**Consultation Response from Alan Smith,
KC Waste Strategy (Refuse & Recycling)**

2025/91959 Butchers Arms, Halifax Road, Staincliffe, Dewsbury, WF13 4AZ

Alterations to former public house and flat to form 8 flats

Responding Ref: WPN 25 021

WF13 4AZ - BUTCHERS ARMS
LAYOUT PLANS
PROPOSALS

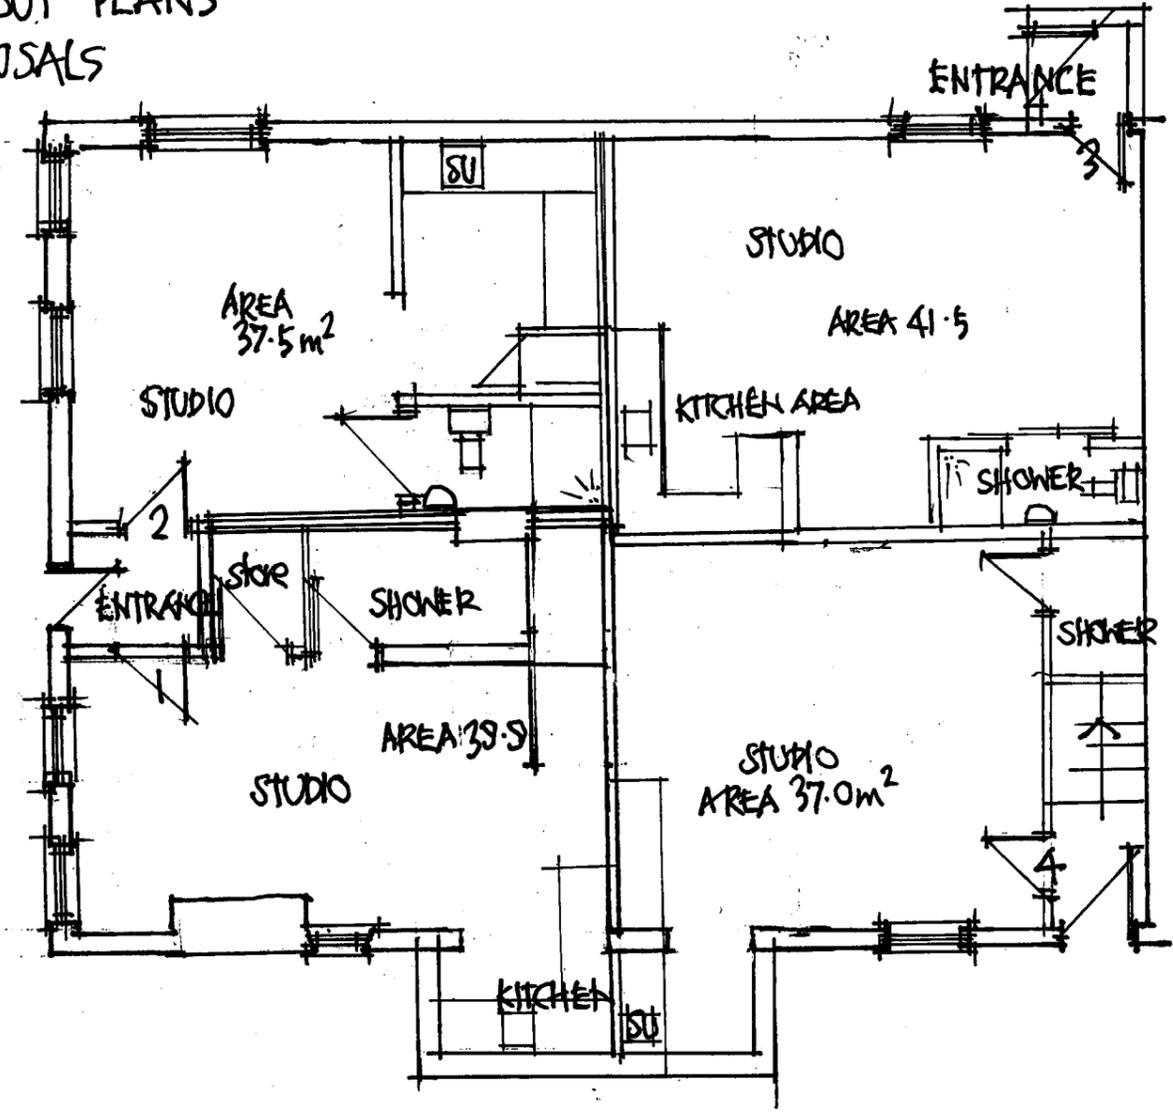
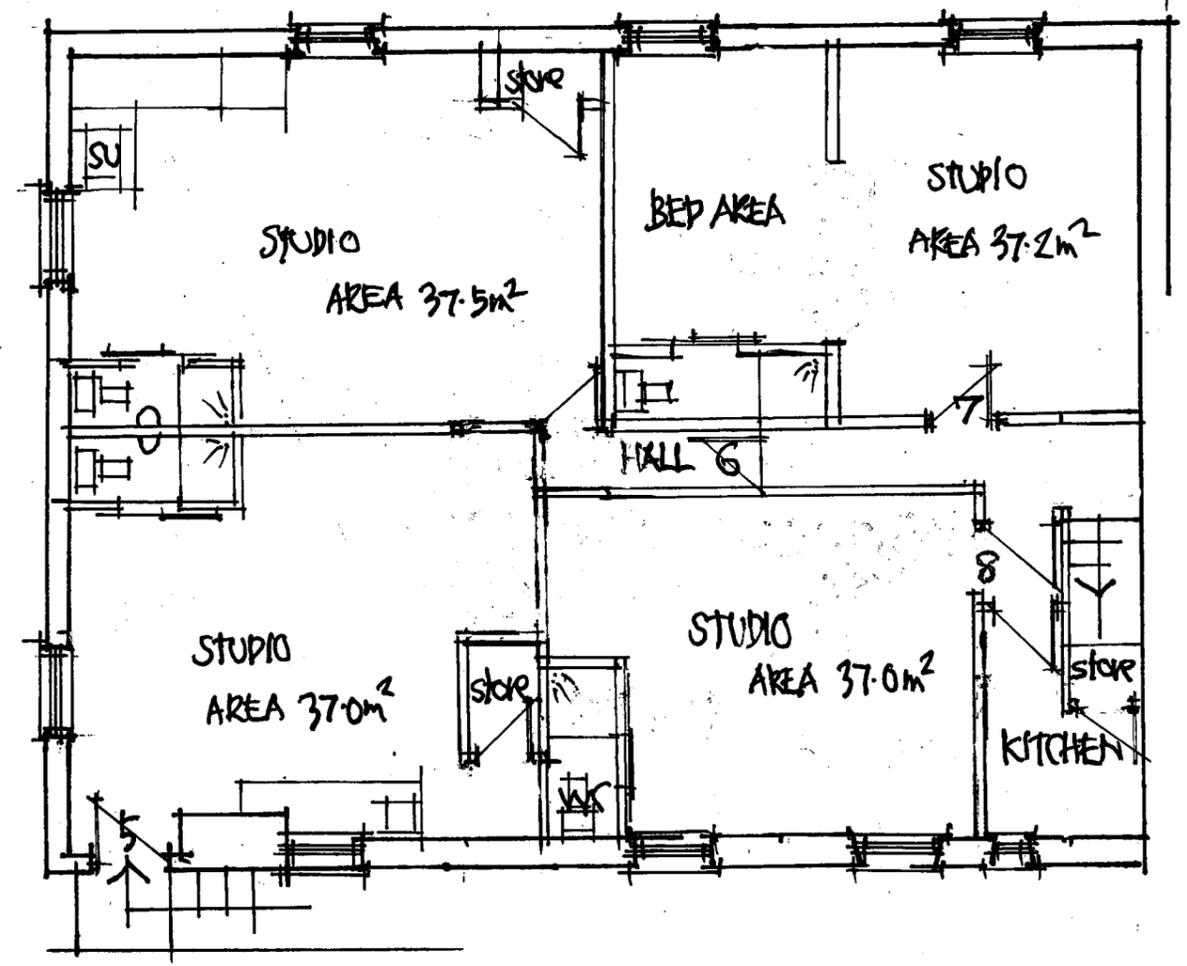
- Layout drawings for this development site will need to show bin storage and presentation points for these flats to demonstrate sufficient space and efficient collection arrangements – these must not cause obstruction to the highway, driveways or be blocked in by cars.

- It appears that there is insufficient space to safely store 3 x 1,100ltr containers in the courtyard to the side of the Butchers Arms off Halifax Road. An alternative would be to create a bin store on the land at the side of the development on Dewsbury Gate Road.

If this space is used, access to the bin store will need to be at pavement level. The crews will not manoeuvre bins down steps or steep slopes.
